Director, Transport Assessments Planning Services  
Department of Planning, Industry and Environment  
GPO Box 39  
Sydney, NSW 2001

**WestConnex M4-M5 Link**  
**Exhibition of Mod 2 – The Crescent overpass and active transport links**  
**Application Number SSI-7485-Mod-2**

Figure 4-4 Elevation: Indicative view of The Crescent overpass

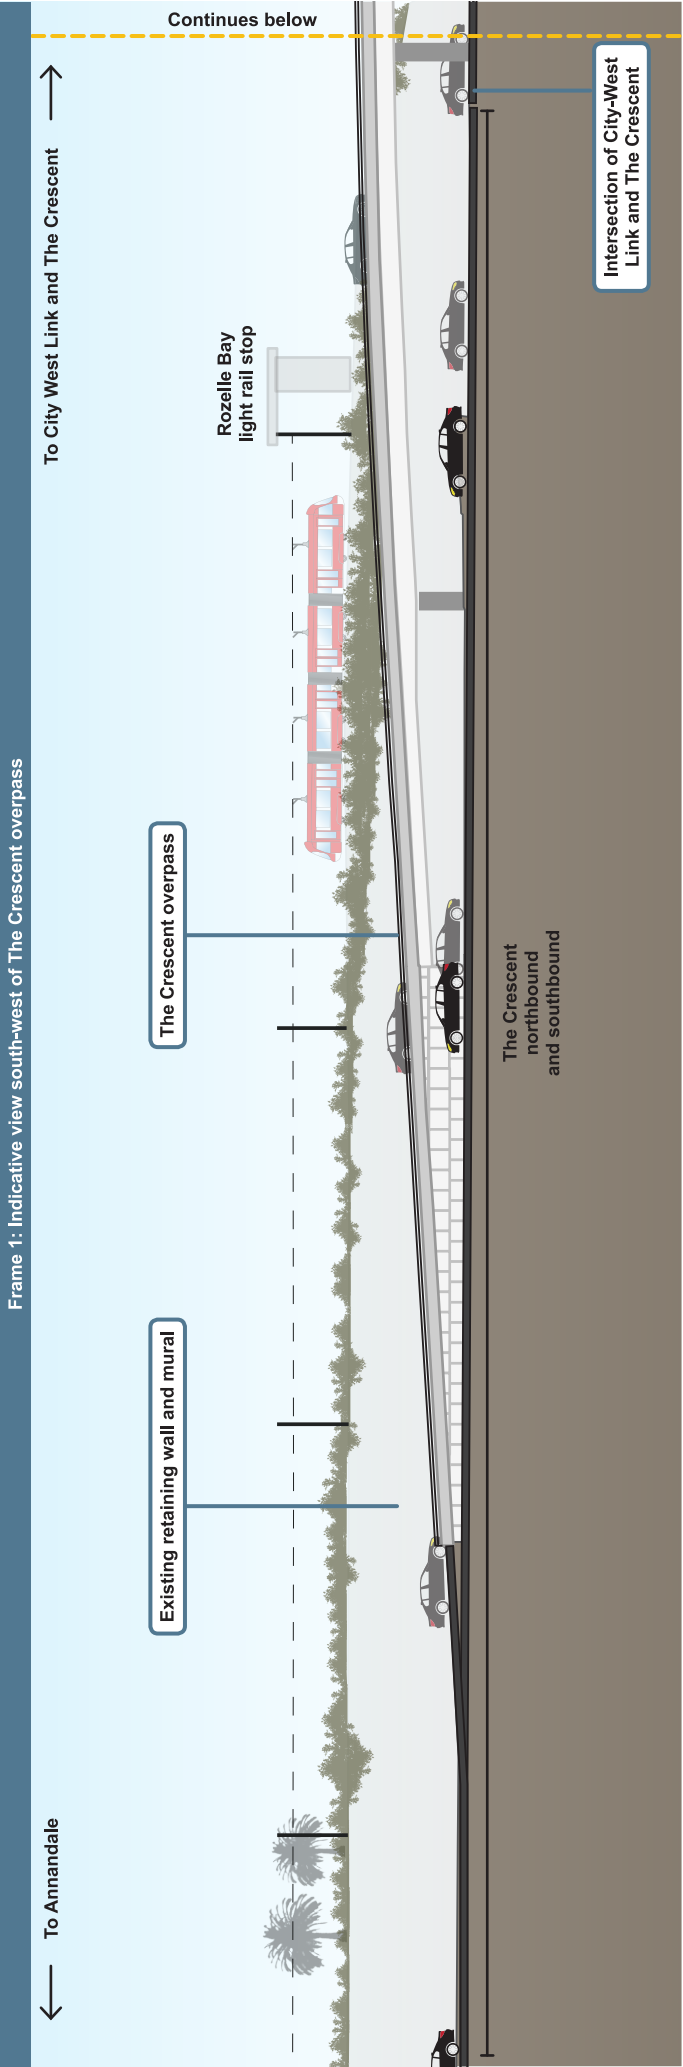
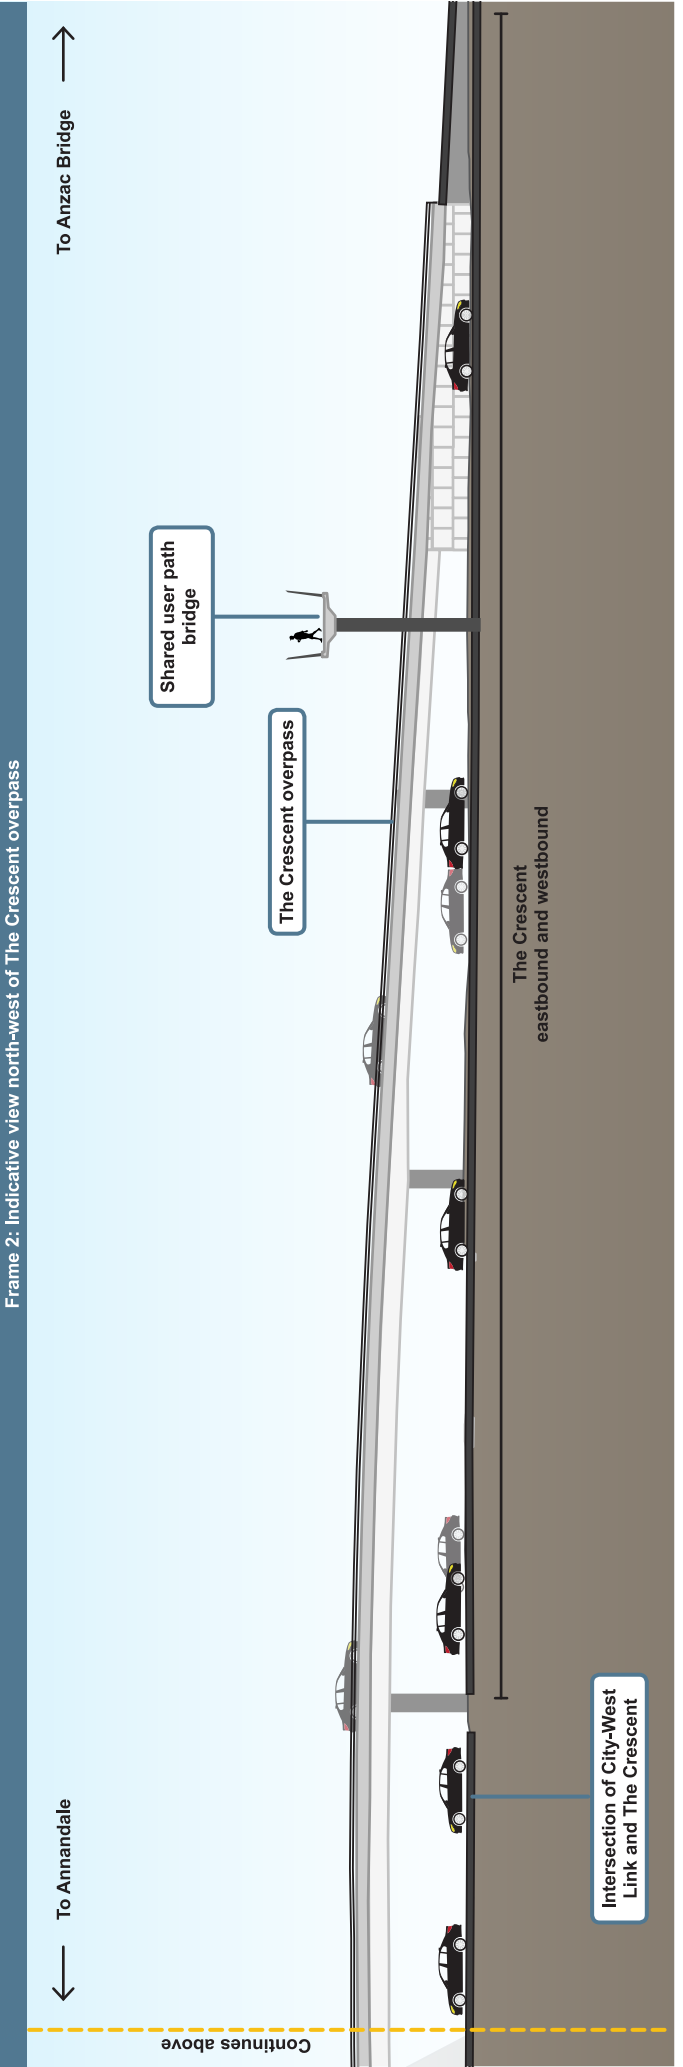
I am opposed to the proposed two level overpass. This is a major variation from the approved design. It will destroy views to the harbor foreshore and increase traffic noise to residences in View Street and other places. If approved, any such overpass must be required to have 'green walls' on both sides of the roadway to minimize its visual impact and to reduce pollution.
